Y/140/20/DOC - Further Drainage Comments

From: Paul Cann <Paul.Cann@arun.gov.uk>
Sent: 27 January 2021 15:55
To: Kazys Narbutas Consulting [REDACTED]
Cc: Ian Sellar [REDACTED]; Simon Davis <Simon.Davis@arun.gov.uk>; John Curry [REDACTED]; Alan Kemp [REDACTED]
Subject: RE: Cinders Nursery Phase 2, Cinders Lane: Planning Consent Y/32/17/OUT

Subject: RE: Cinders Nursery Phase 2, Cinders Lane: Planning Consent Y/32/17/OUT

HB1, Hydro Brake Manhole & Discharge from Sub Base Attenuation Details

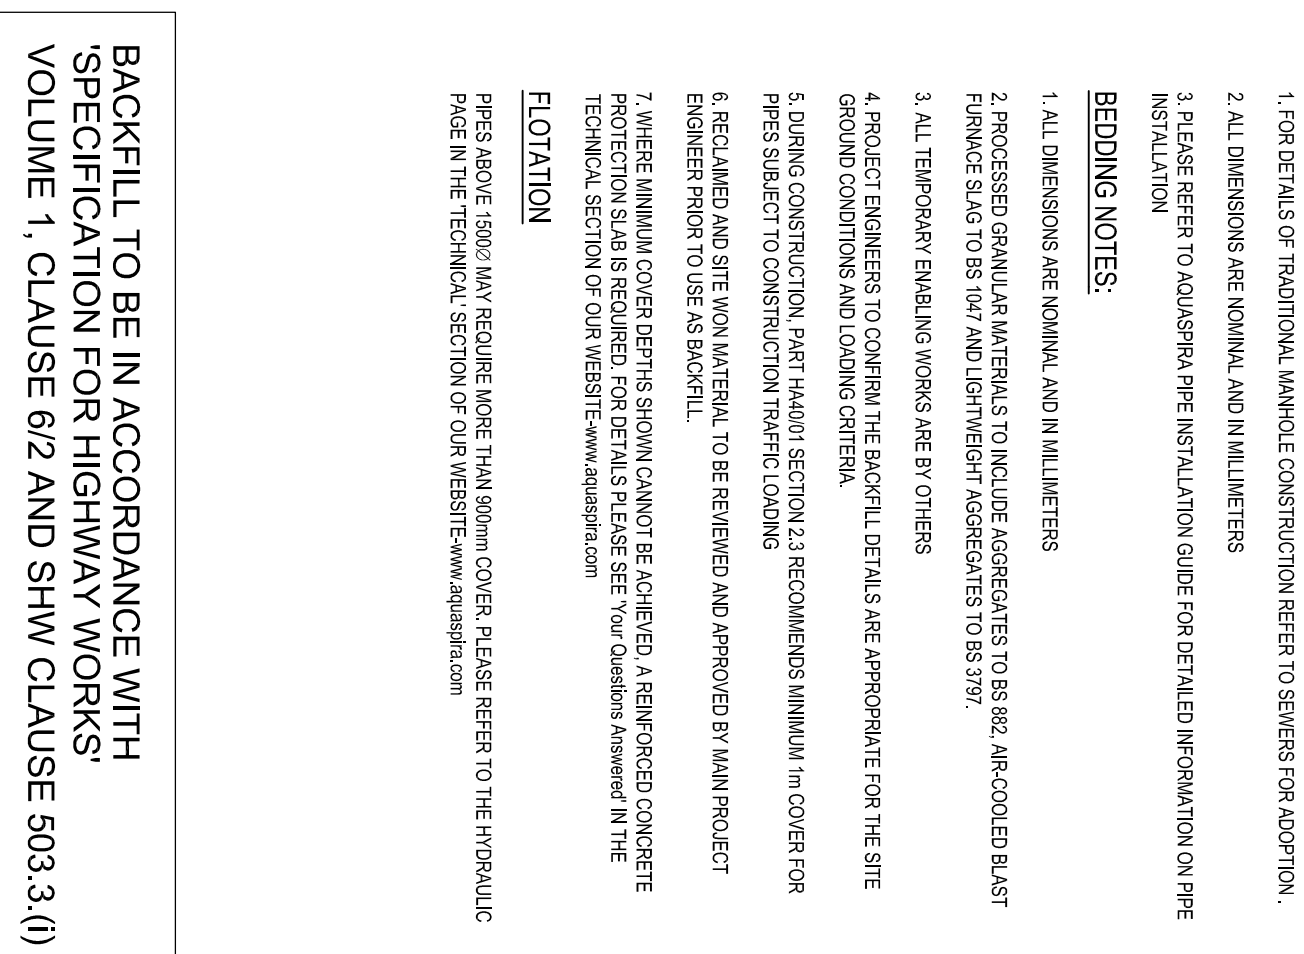
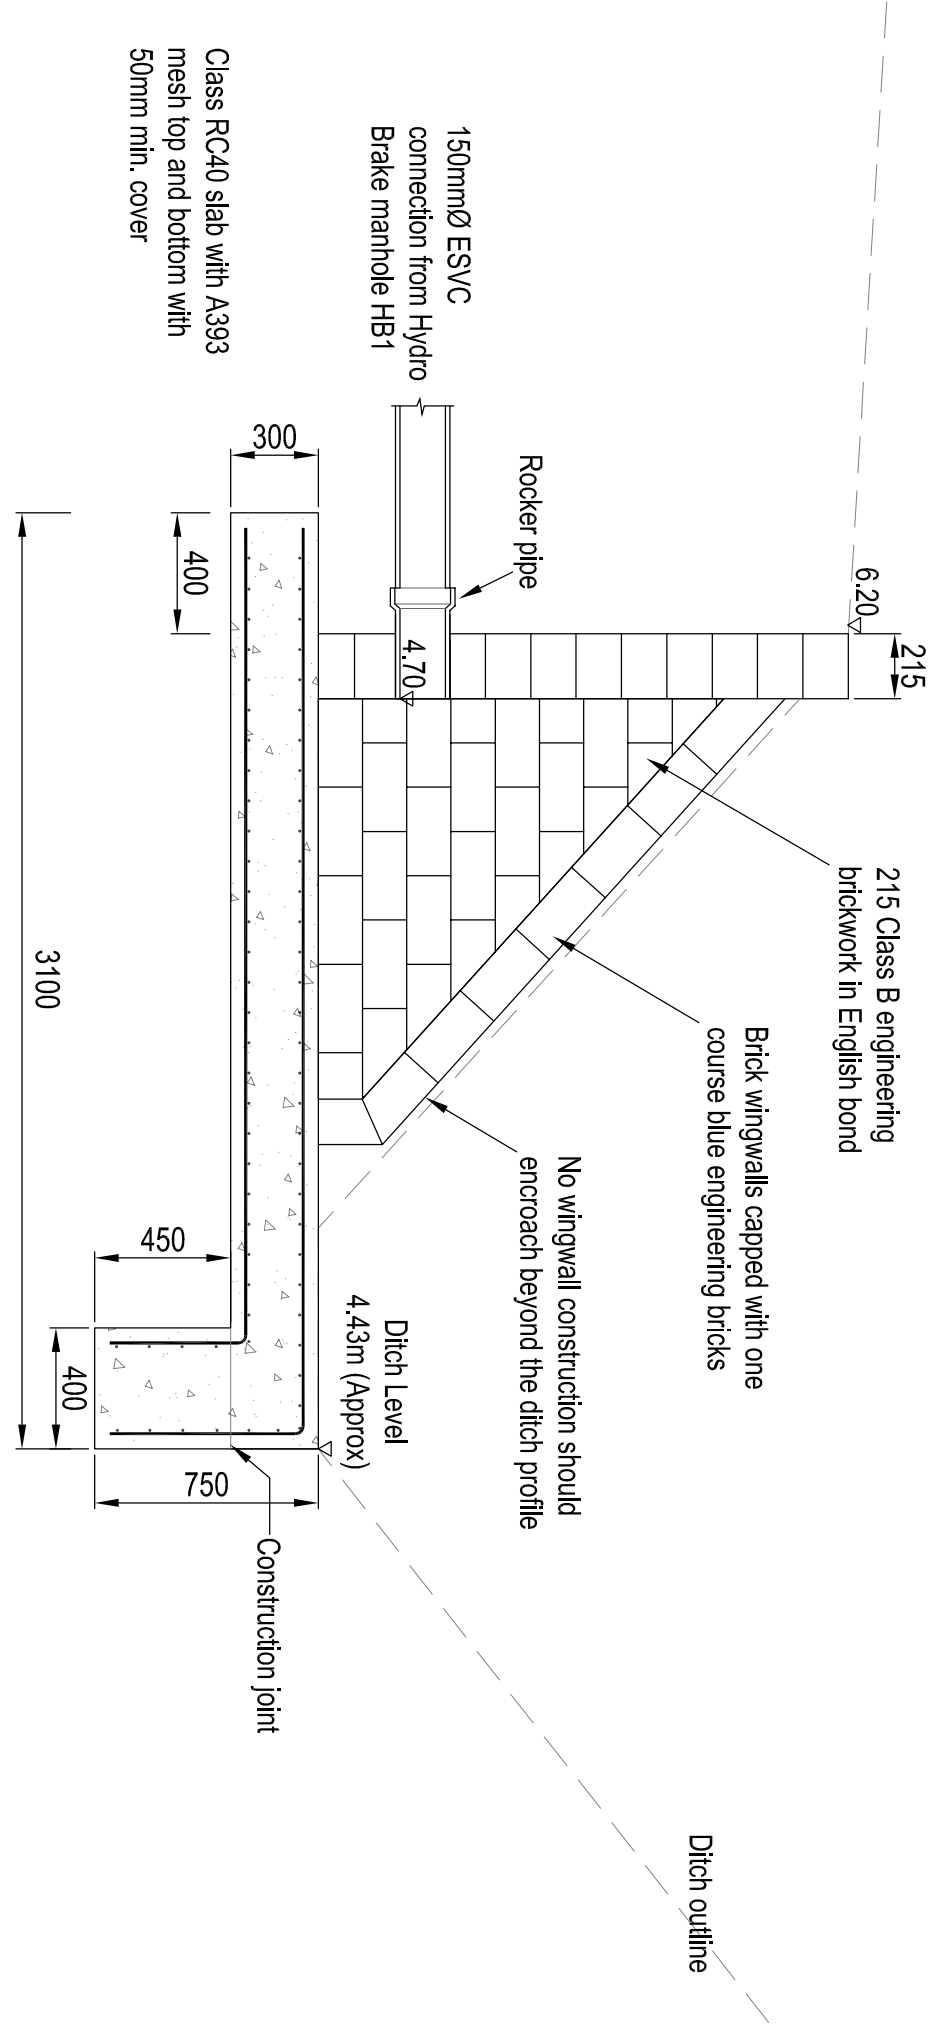
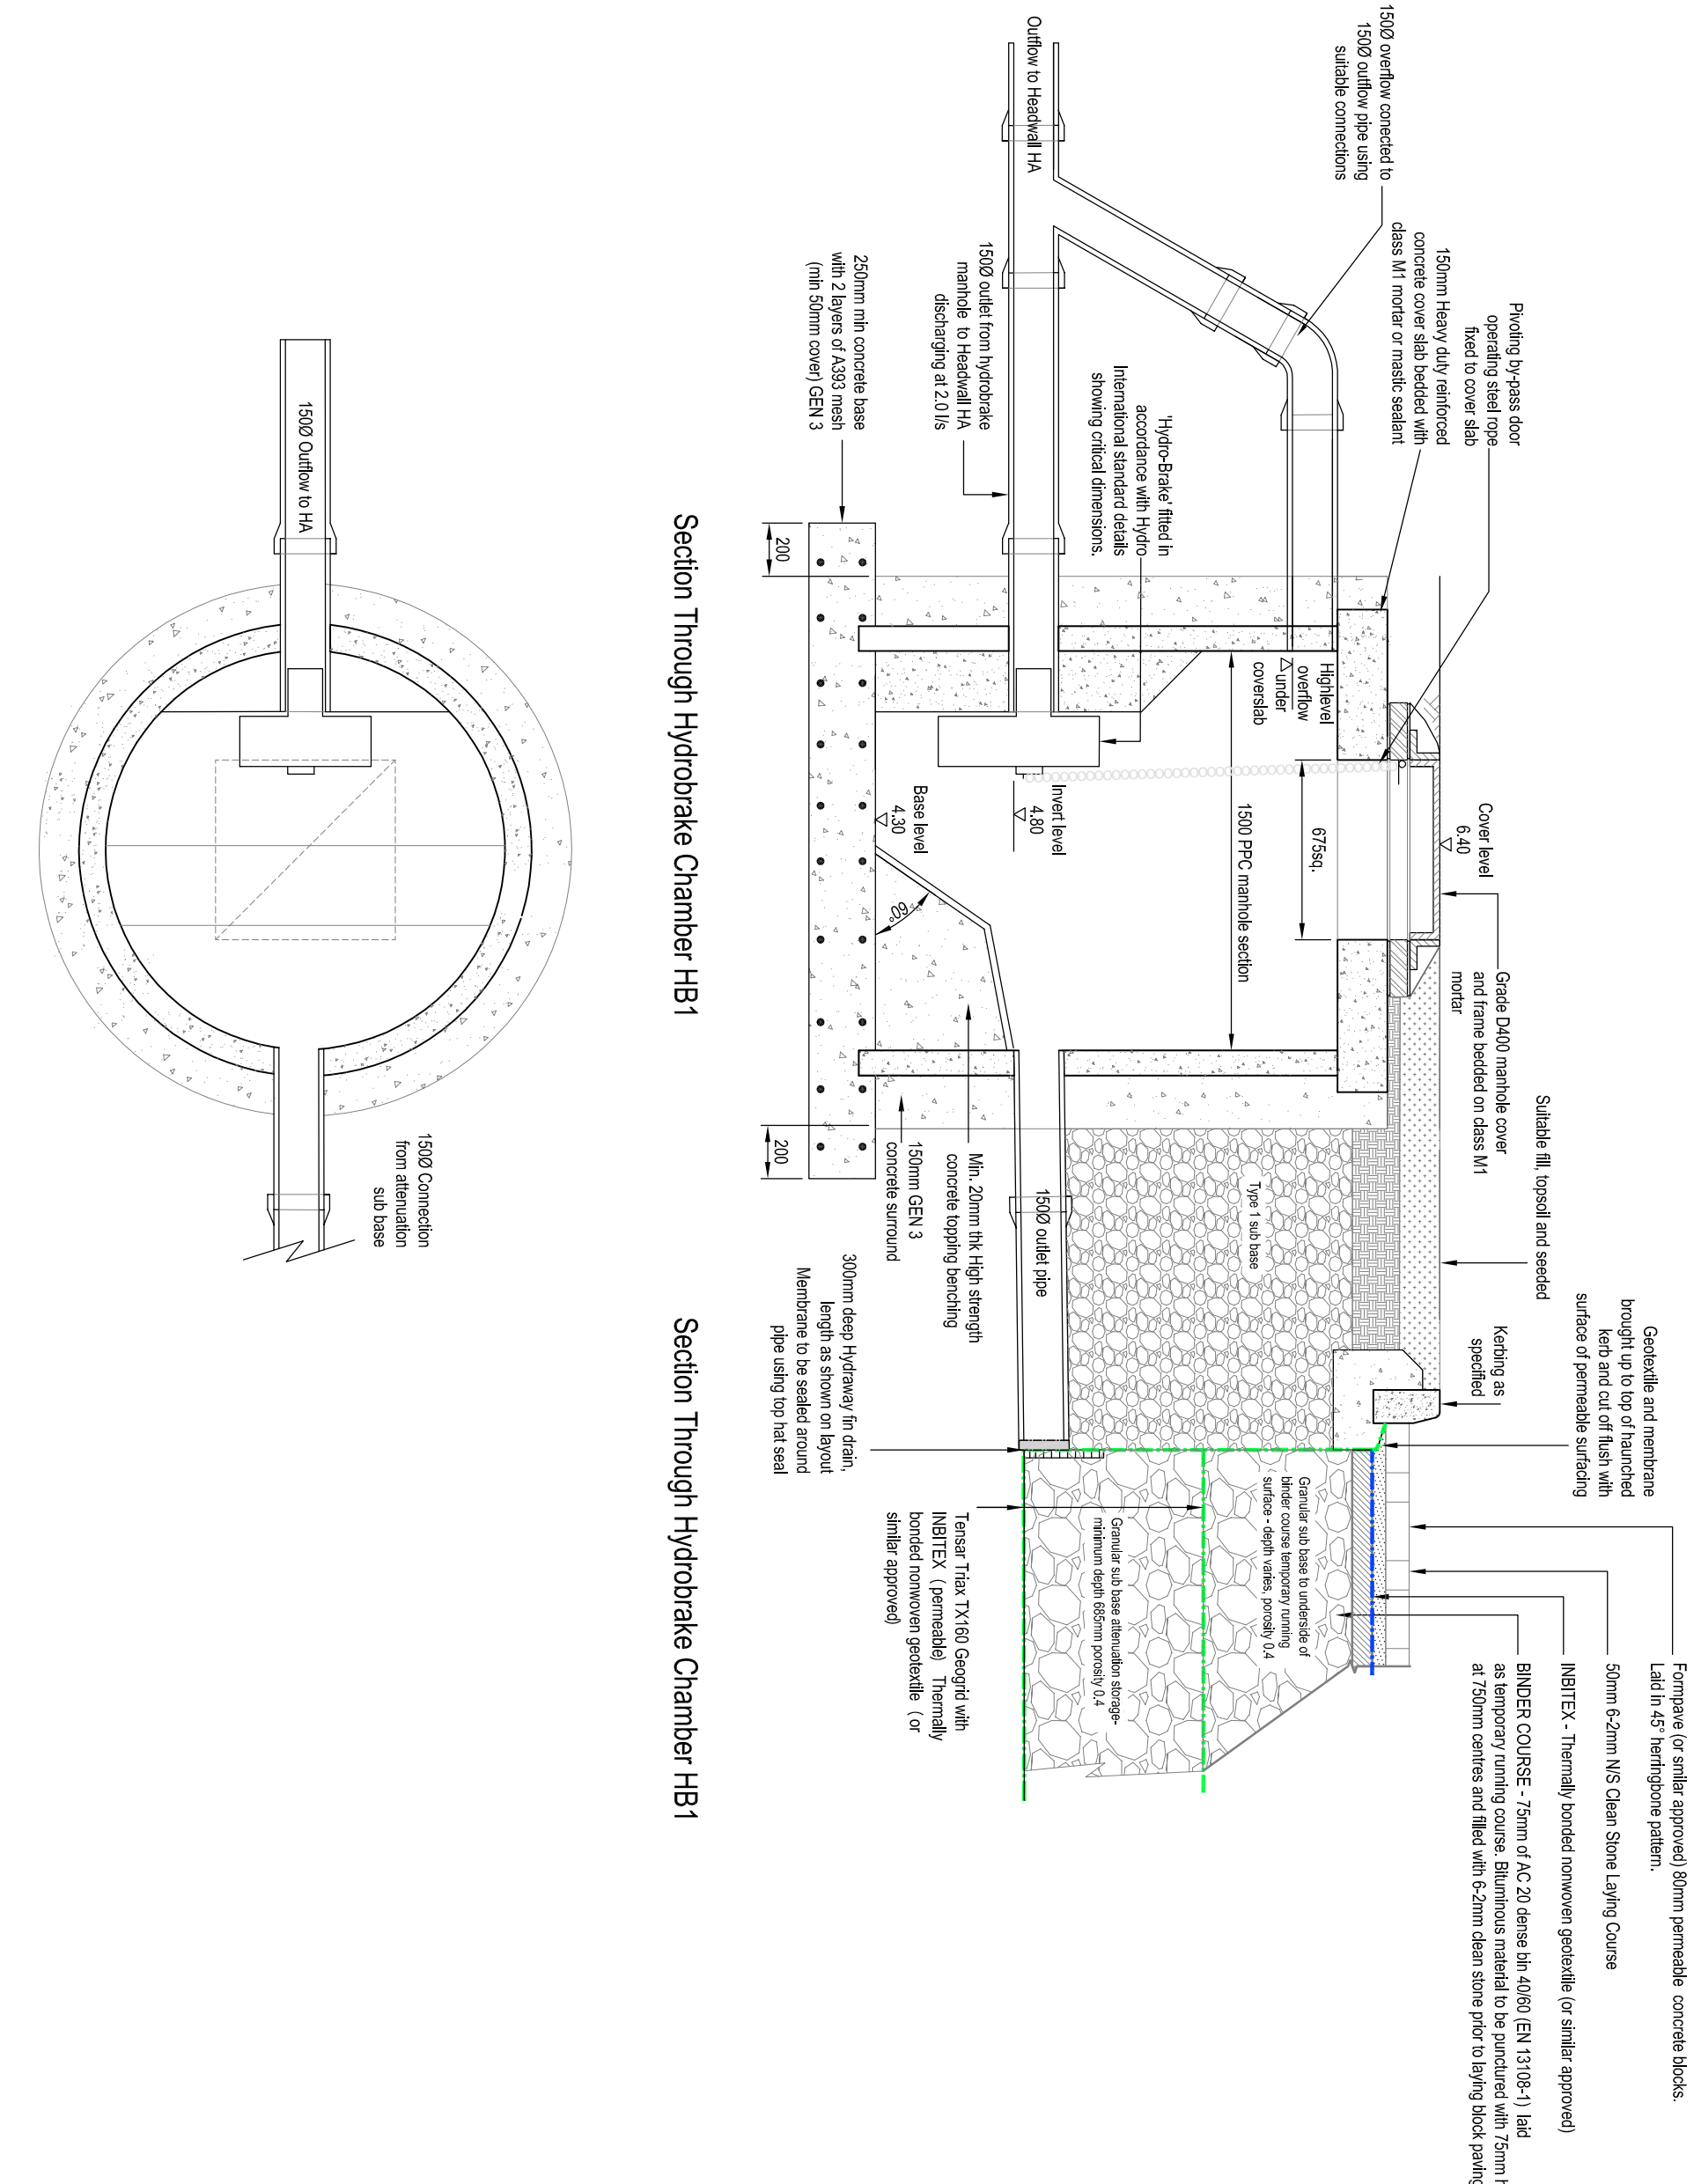
28. Specify hydrobrake model on HB1 construction detail drawing. Specify ST4 concrete base, benching and block for hydrobrake fixing. Specify overflow invert level and surround pipe in min. 150mm thick ST4 concrete. Include step rungs. Specify class B engineering brickwork under cover/frame. Hydro Brake model specified and all other comments incorporated on drg KNC2006-501-03 Rev B ok but alter reference to headwall HA to H2.

Drawing Title				
Engineering Details				
Standard Construction Details				
Drawing	Contract	Scale	Paper Size	Date
KN		As Shown	A1	12.18
Job No.	Drawing No.		Revision	
KNC2006	501-01		B

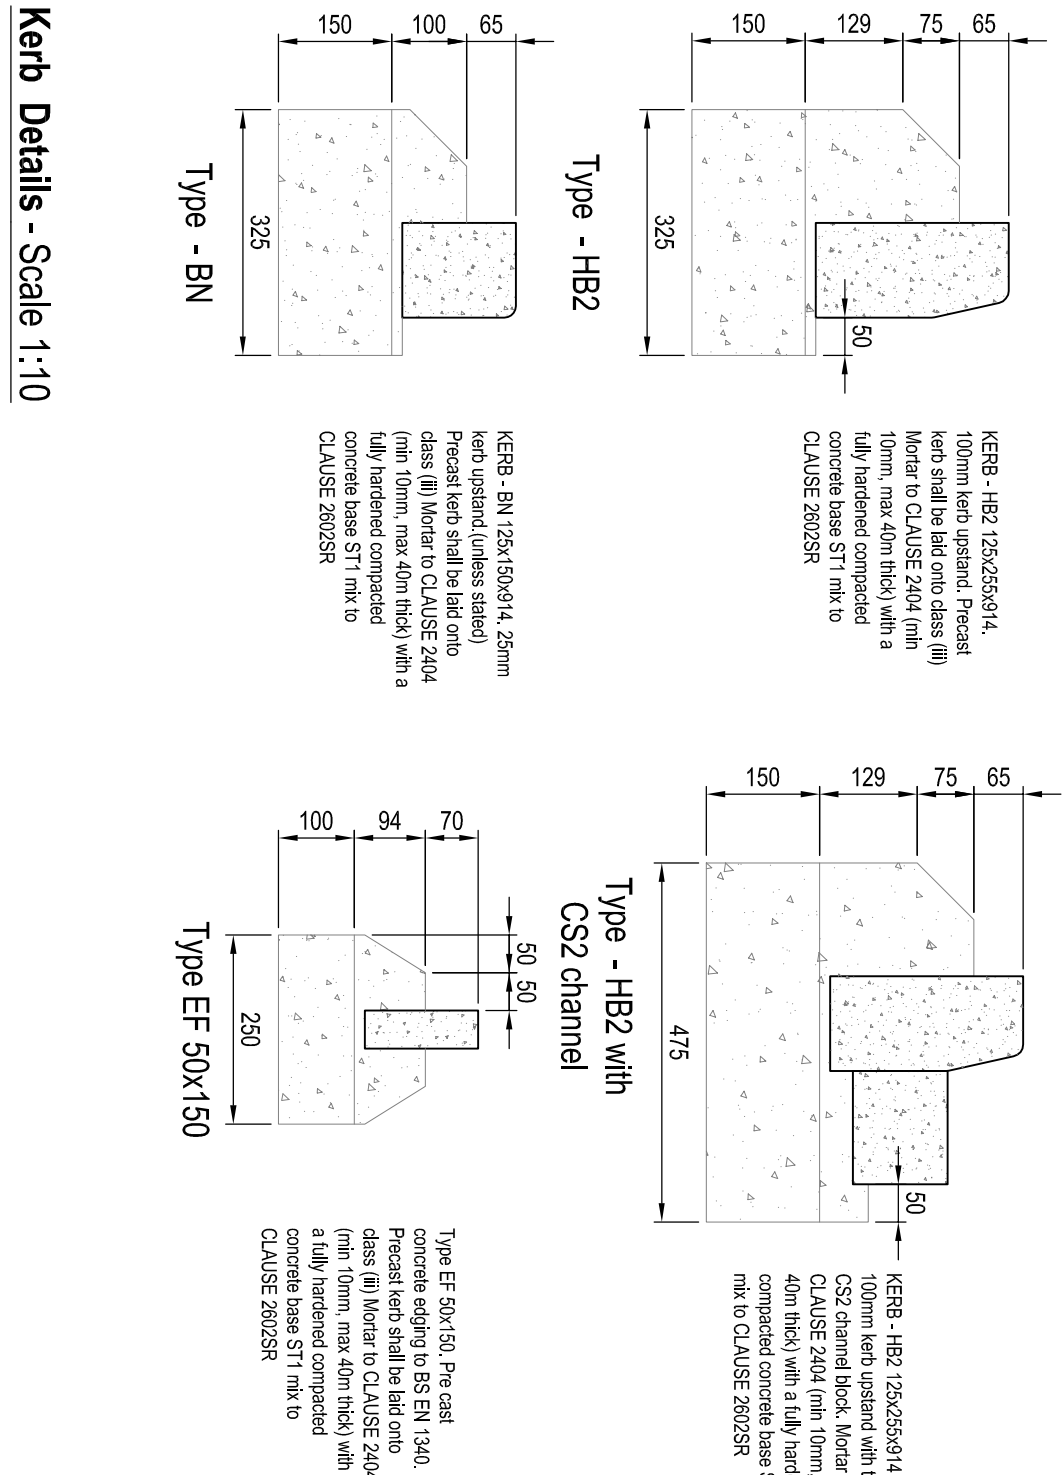
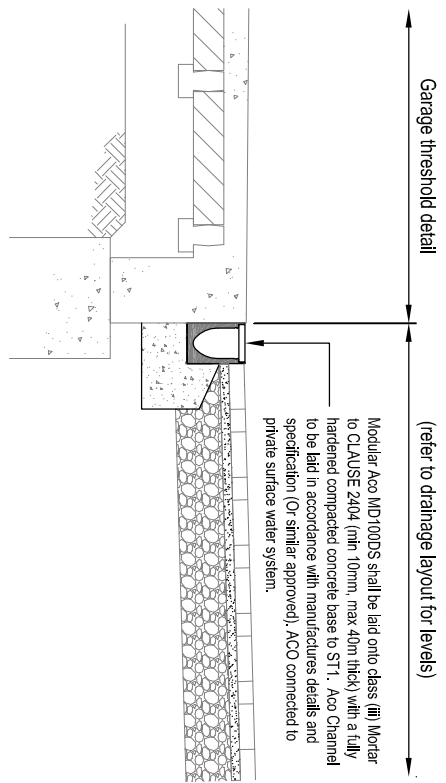
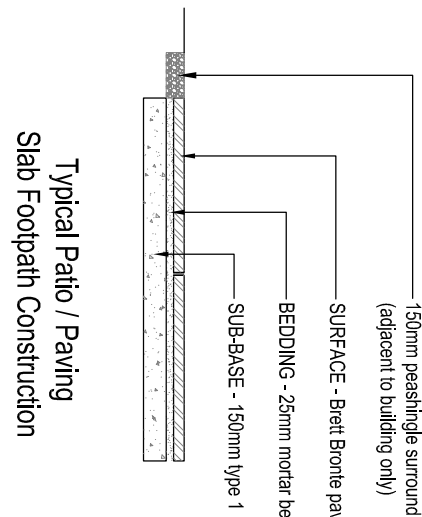
26. Drawing 501-03 Rev A - Aquire Spire storage pipe detail not relevant – delete. This detail has been removed from the drawing ok
27. Drawing 501 01 Rev B – permeable block paving detail type 3 not relevant? – delete There is an area of permeable block paving which is situated at the eastern end of the site and in the lay-bys. It is identifiable on the drainage layout and also on the attached surfacing drawing KNC2006-507-01 Rev B. Noted but type 1 material is specified within the construction which is not permeable ie. how does water reach the attenuation sub base? I assume this is a typo as drg. KNC2006/501-03 Rev B shows a porous granular sub base.
